Project Name: THE PALISADES

**CITY OF ALBUQUERQUE
PLANNING DEPARTMENT
April 9, 2008
DRB Comments**

RE: Lot 14, Block G, The Palisades

PLAT OF
 LOTS 14-A & 14-B, BLOCK G
 THE PALISADES
 Projected Section 11, T10N, R2E, NMPM
 Town of Atrisco Grant
 City of Albuquerque
 Bernalillo County, New Mexico
 March 2008

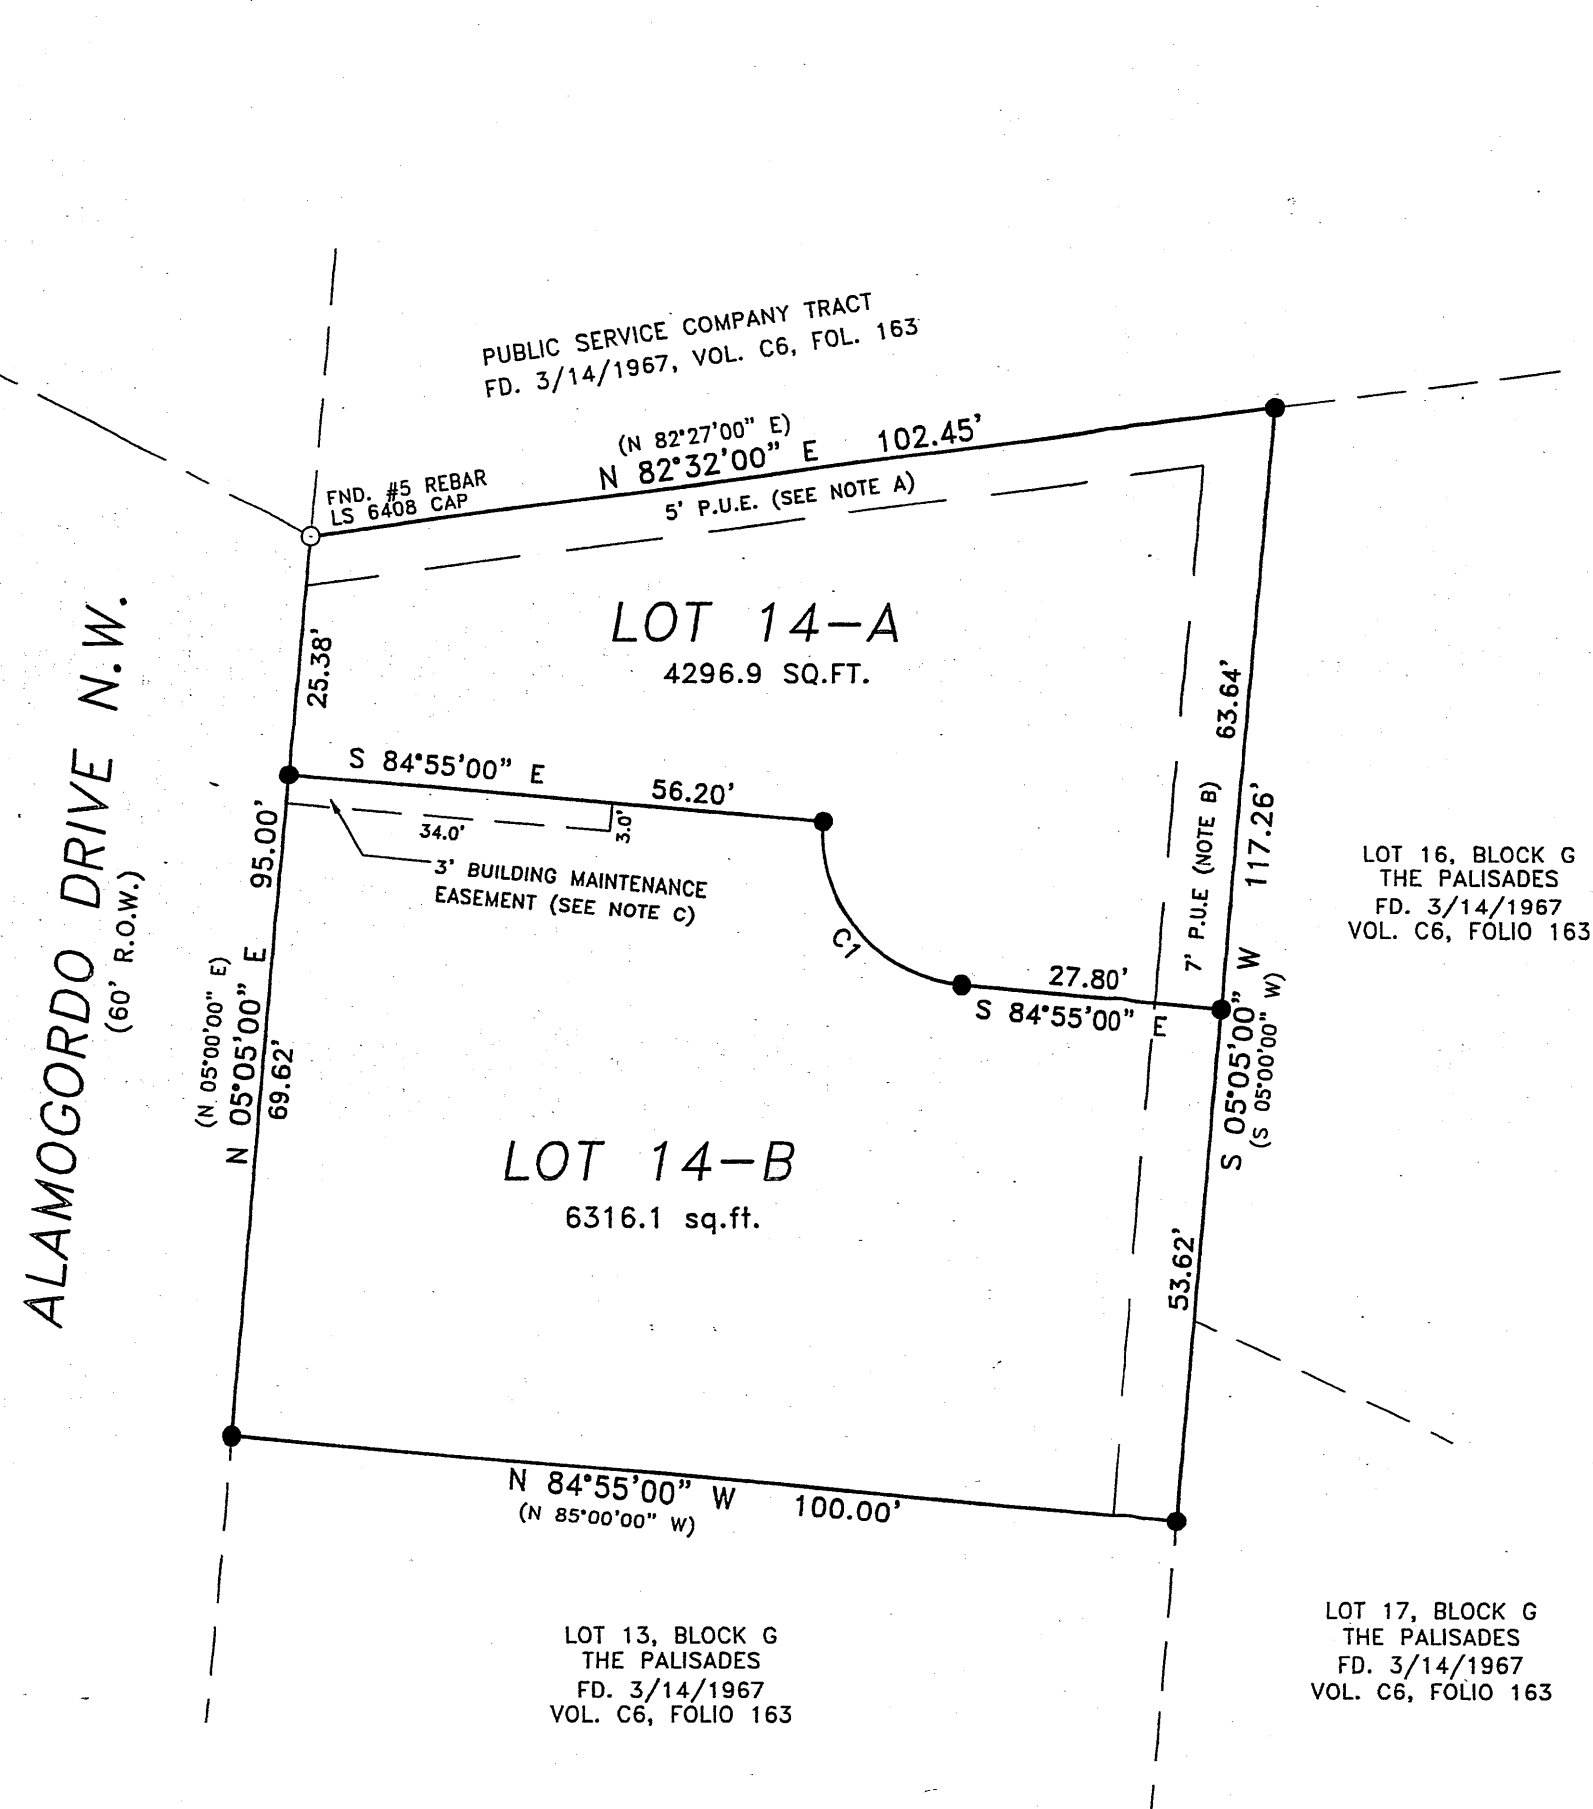
CITY ENGINEER / AMAFCA: cross-lot drw esmt
3' building maintenance esmt

PLAT OF
 LOTS 14-A & 14-B, BLOCK G
 THE PALISADES
 Projected Section 11 T10N, R2E, NMPM
 Town of ~~Atrisco~~ Grant
 City of Albuquerque
 Bernalillo County, New Mexico
 March 2008

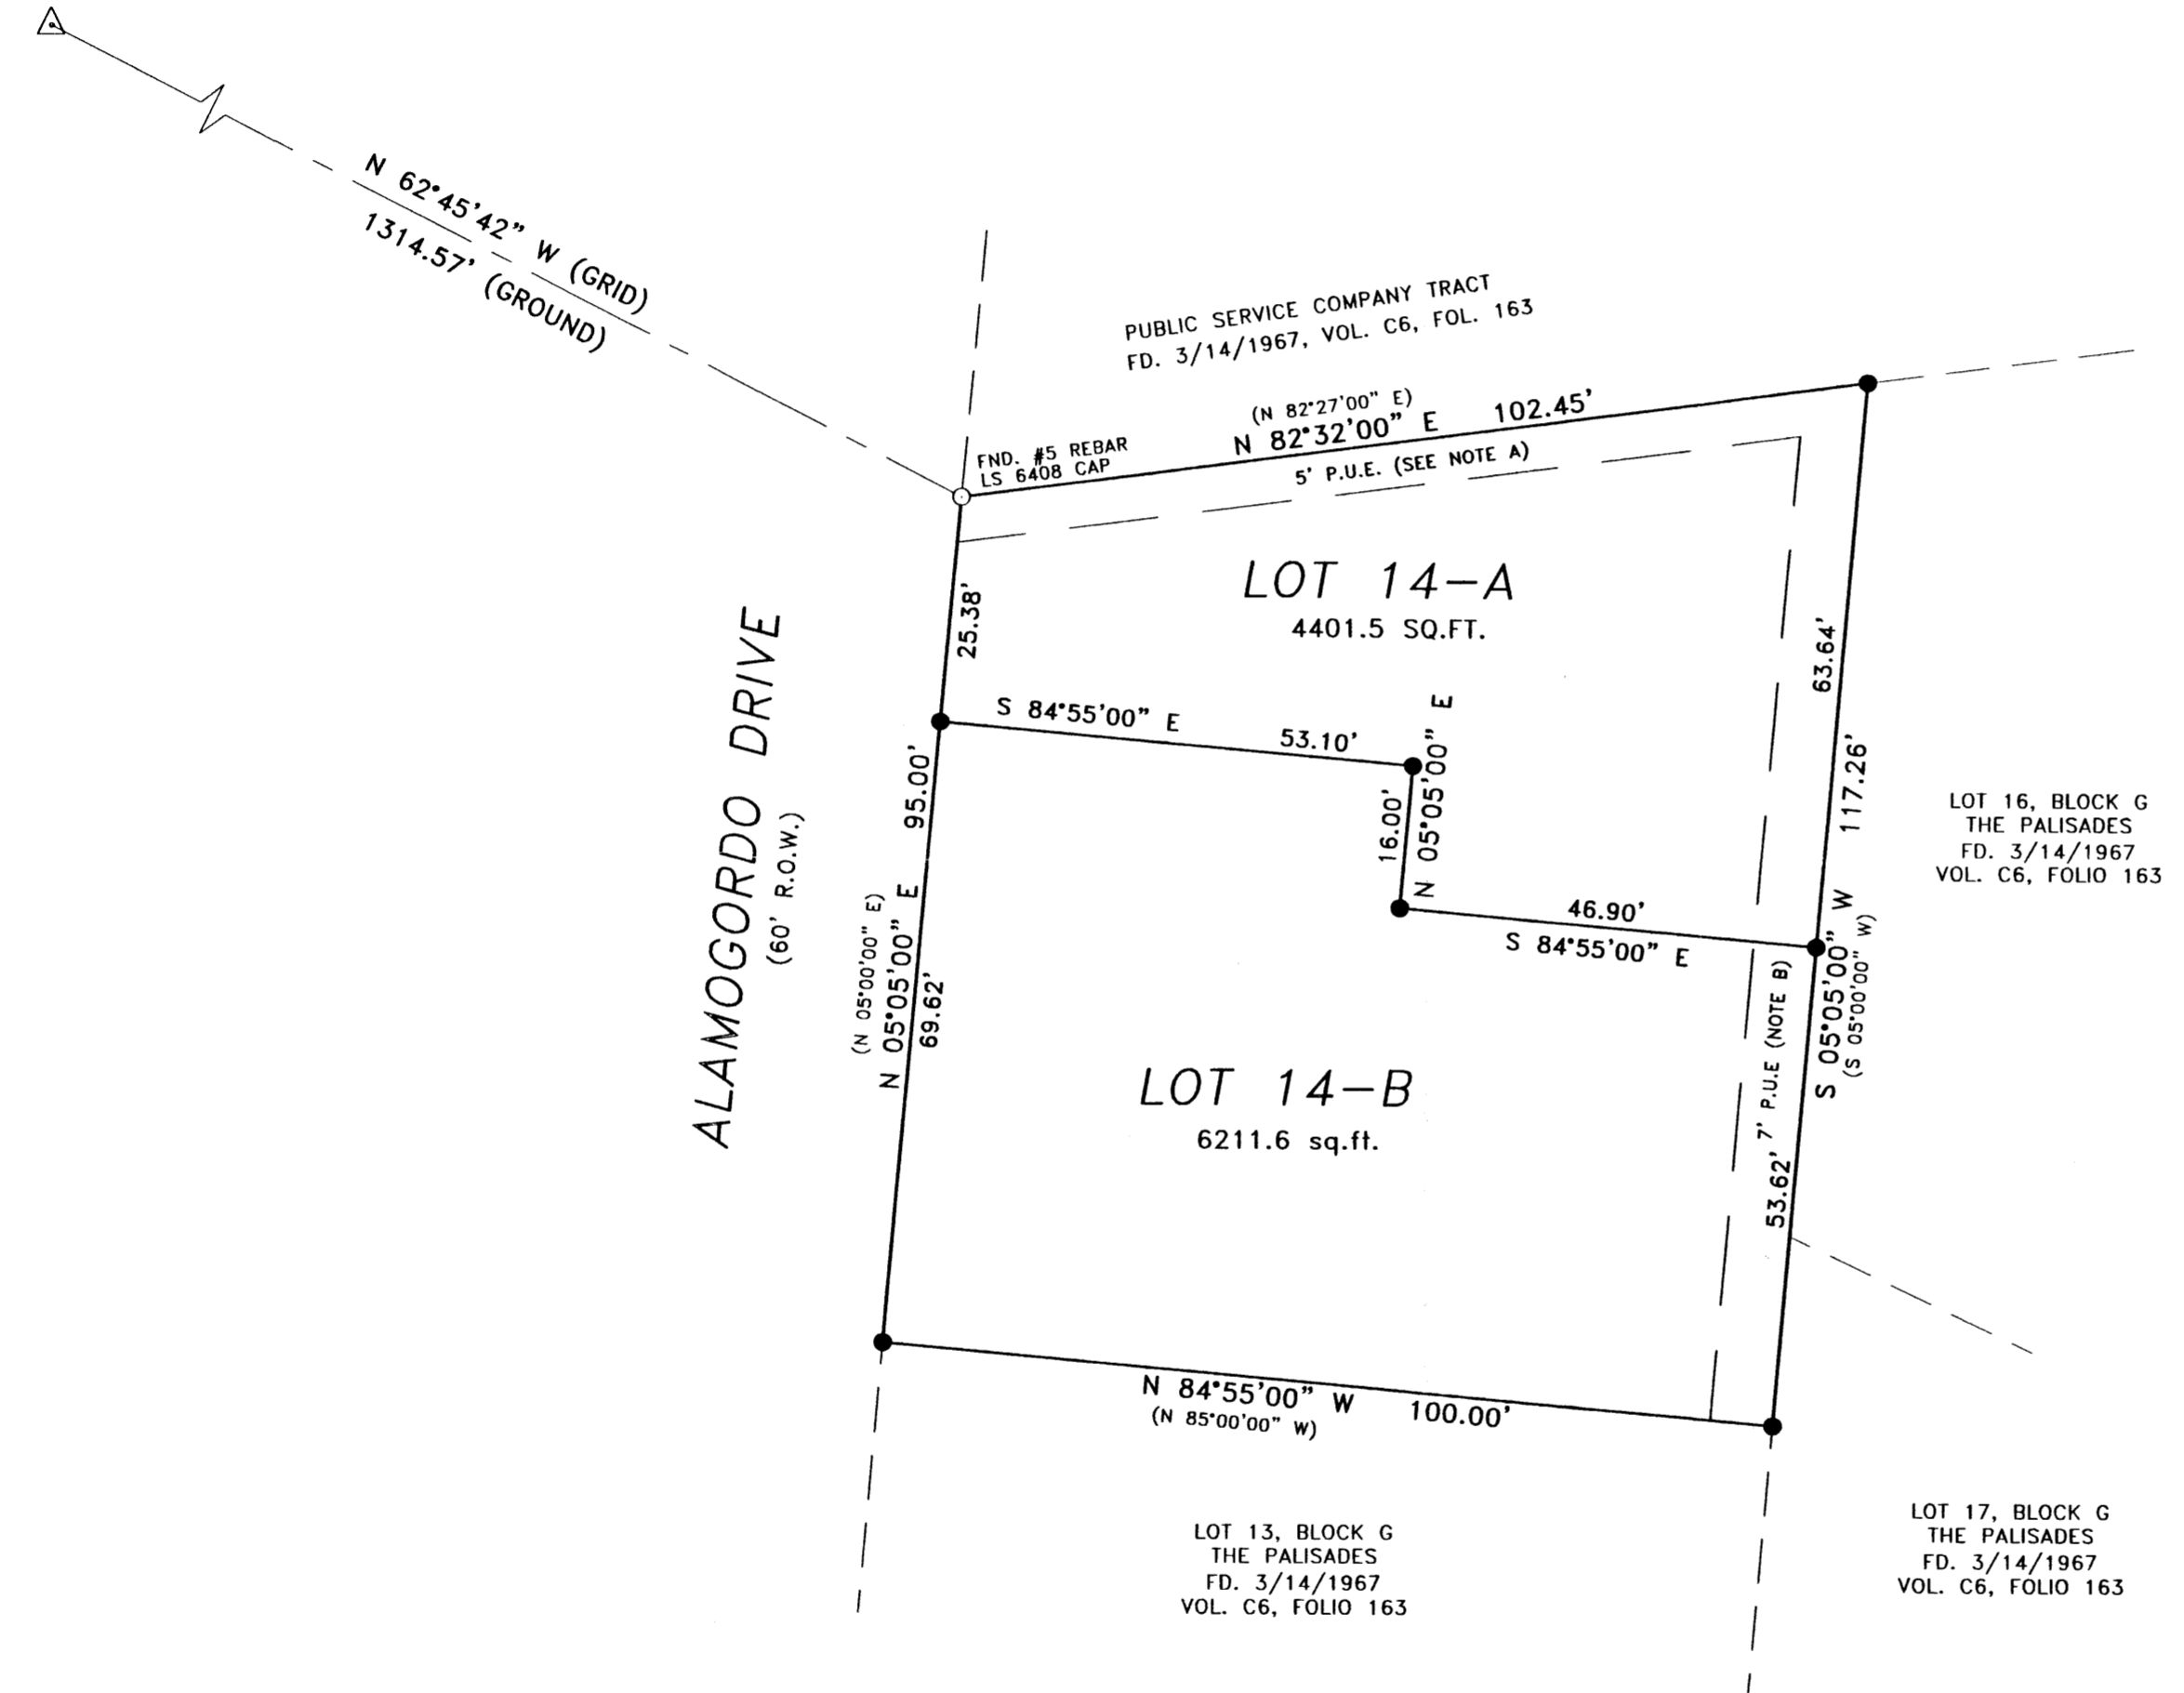
Certification is needed that existing building meets the Building Code for zero lot line/ townhouse construction on proposed lot line.

For future reference, please do not identify the property's zoning (Note 8) on the plat. Also, please revise solar note to be specific to this type of request, i.e. use the words "THIS PLAT" and not "REQUESTED FINAL ACTION" and do not use the words "OR SITE DEVELOPMENT PLAN FOR SUBDIVISION" at the end of the note.
